2023/0781

Alta Vista, Lund Lane, Lundwood, Barnsley, S71 5PE

Erection of dormer, single storey rear extension, two storey porch, balcony to dwelling, garage conversion and supporting boundary wall

3 PROPOSED SECTION OF SUPPORTING WALL  
1 : 50

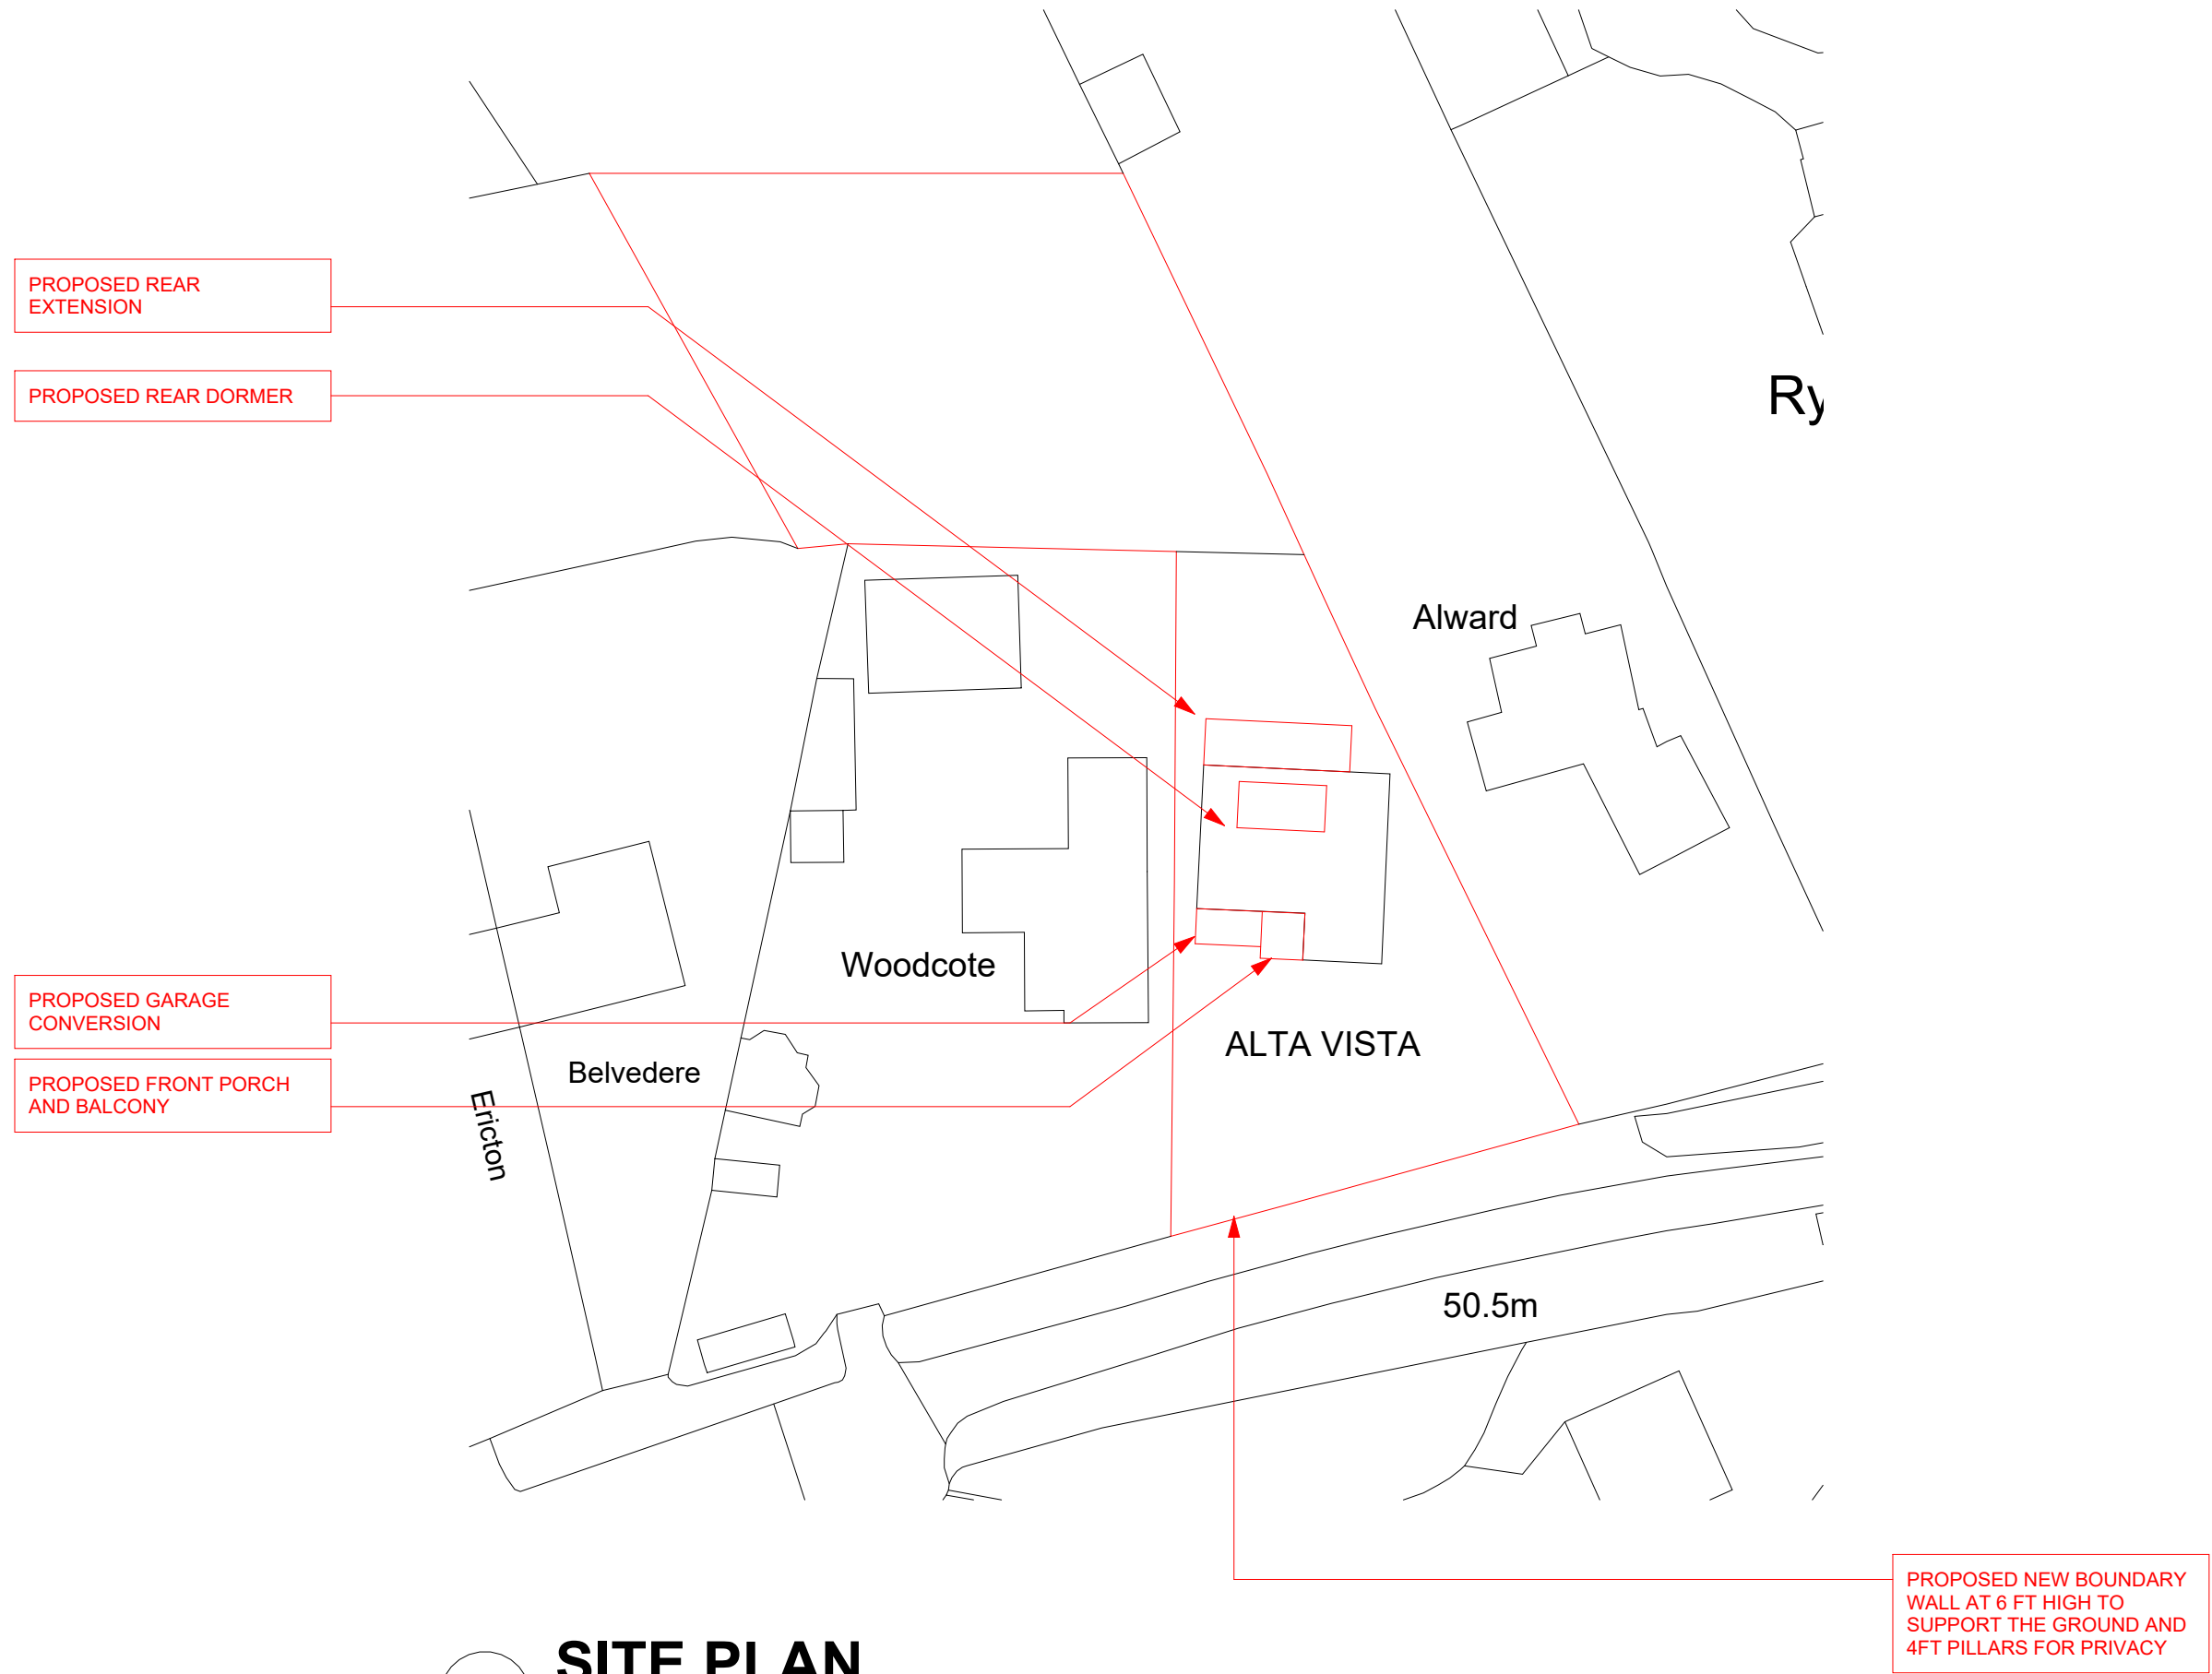
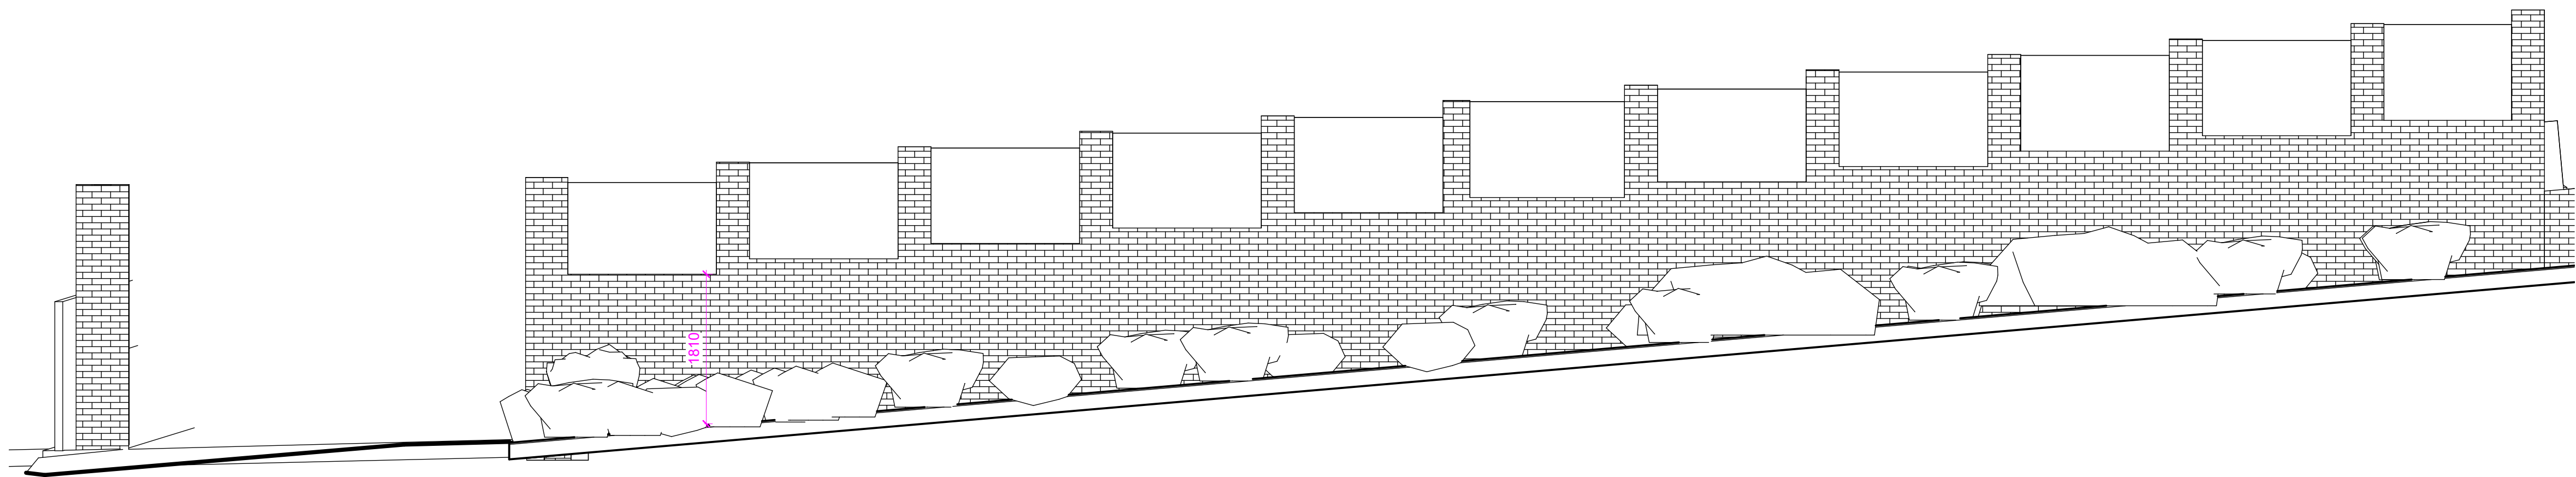
The main issue to consider regarding the boundary wall is the impact the wall would have on the character of the street scene. The dwelling fronts onto Lund Lane as does the adjacent dwellings. The applicant seeks permission to provide an enclosed parking area to the property via the installation of a new wall. The main impact of this will be on the street scene of Lund Lane. The previous boundary treatment is a tree line however the dwellings to the west have a low wall topped with fencing which is a stark contrast from the tree line.

Although a wall to the height of the proposed isn't present in the street scene the proposal will not be significantly detrimental to visual amenity as the same style of boundary treatment is maintained. The wall has been reduced in height to 2.4 metres. Therefore, although of a slightly greater height due to the uniformity of design it will not form an anomalous and alien feature in the street scene. Additionally, replacement planting behind the wall is to be conditioned. The proposed development is therefore not considered to be contrary to Local Plan Policy D1: High Quality Design and Place Making and is considered acceptable in terms of visual amenity.
